Rezoning Transportation Analysis

Petition Number: 2017-118

General Location Identifier: 04115106

Date	Description
08-16-17	First Review, KLA
11-30-20	Second Review, EL
01-22-21	Third Review, EL

DATE: 01/11/21
FILE: M21014
DRAWN BY: RST
REVISED:
JOB NO: _____
SHEET: RZ-1
OF: _____

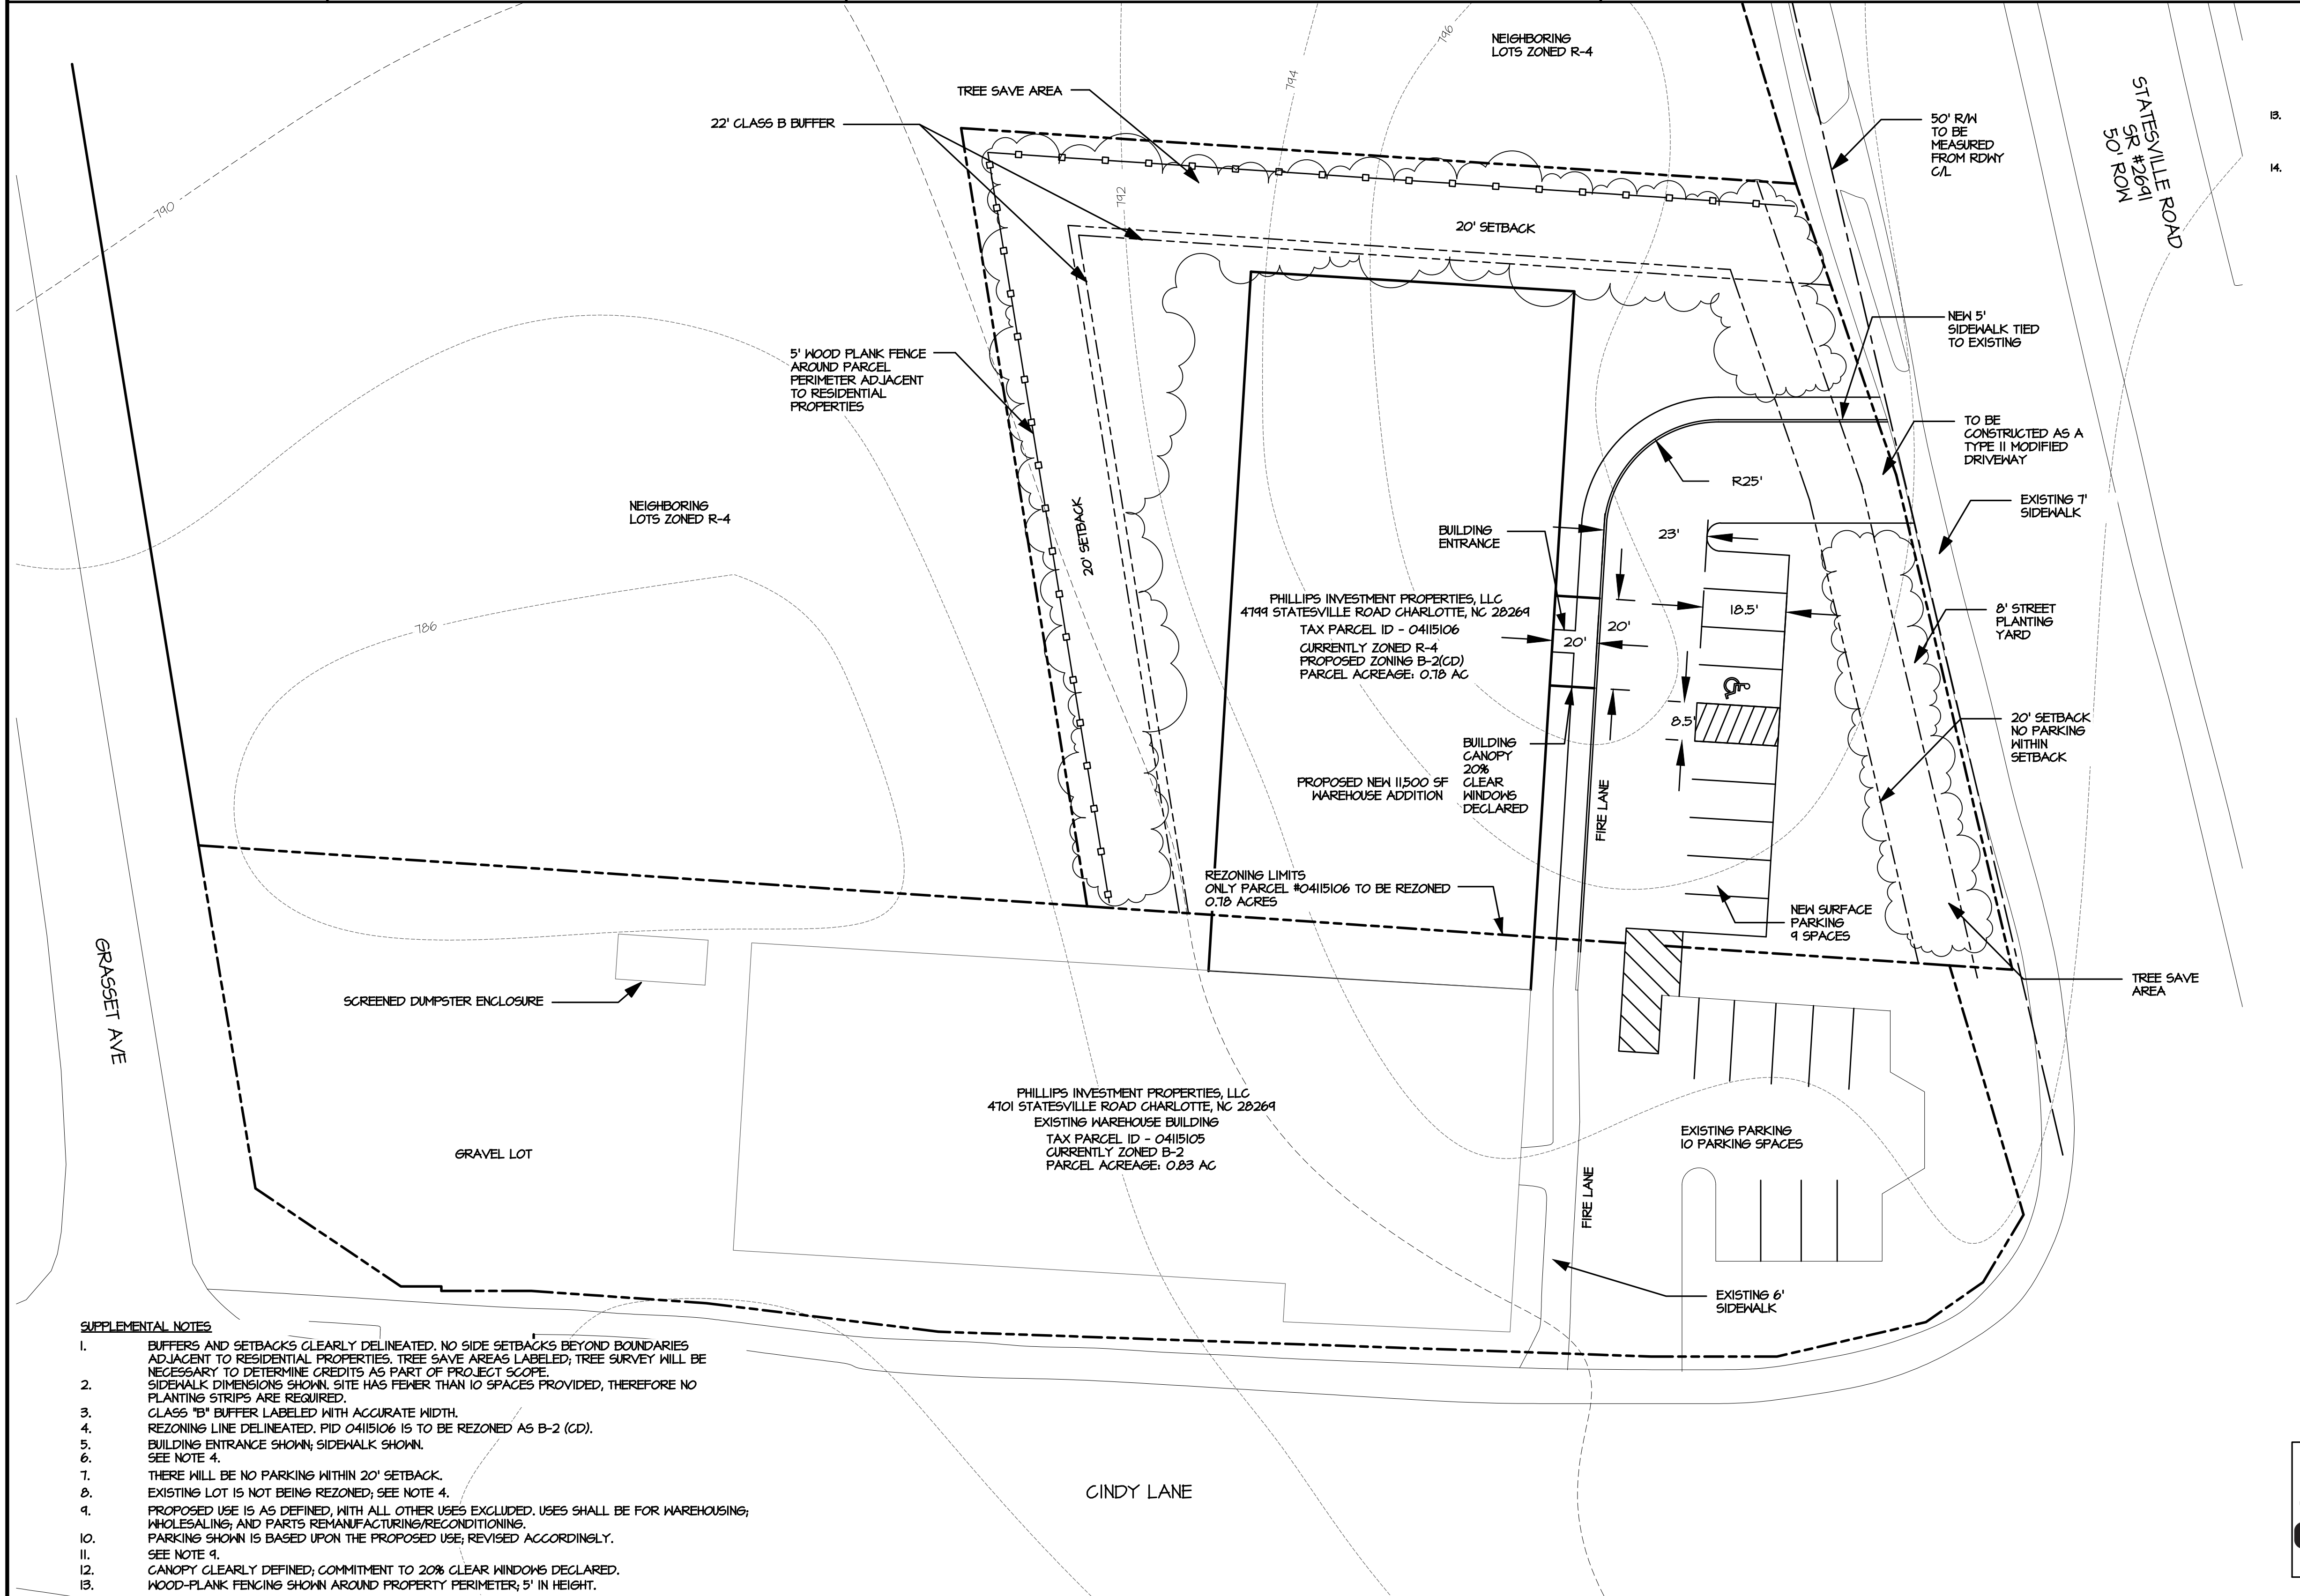
3. **Outstanding Comment (site plan dated 05/11/20)** If large trees are removed, the petitioner should reconstruct to an 8' planting strip and 6' sidewalk along frontage, as required by Chapter 19 of the City Code. The proposed planting strip must be a minimum of 8' in width. The 6' sidewalk may meander around the existing trees, if contained within a sidewalk-utility-easement, which is to be placed 2' from the proposed back-of-sidewalk. The planting strip must be installed between the existing back of curb and proposed sidewalk.

4. **Outstanding Comment (site plan dated 05/11/20)** Revise the site plan to dimension the proposed right of way dedication from the Statesville Road centerline.
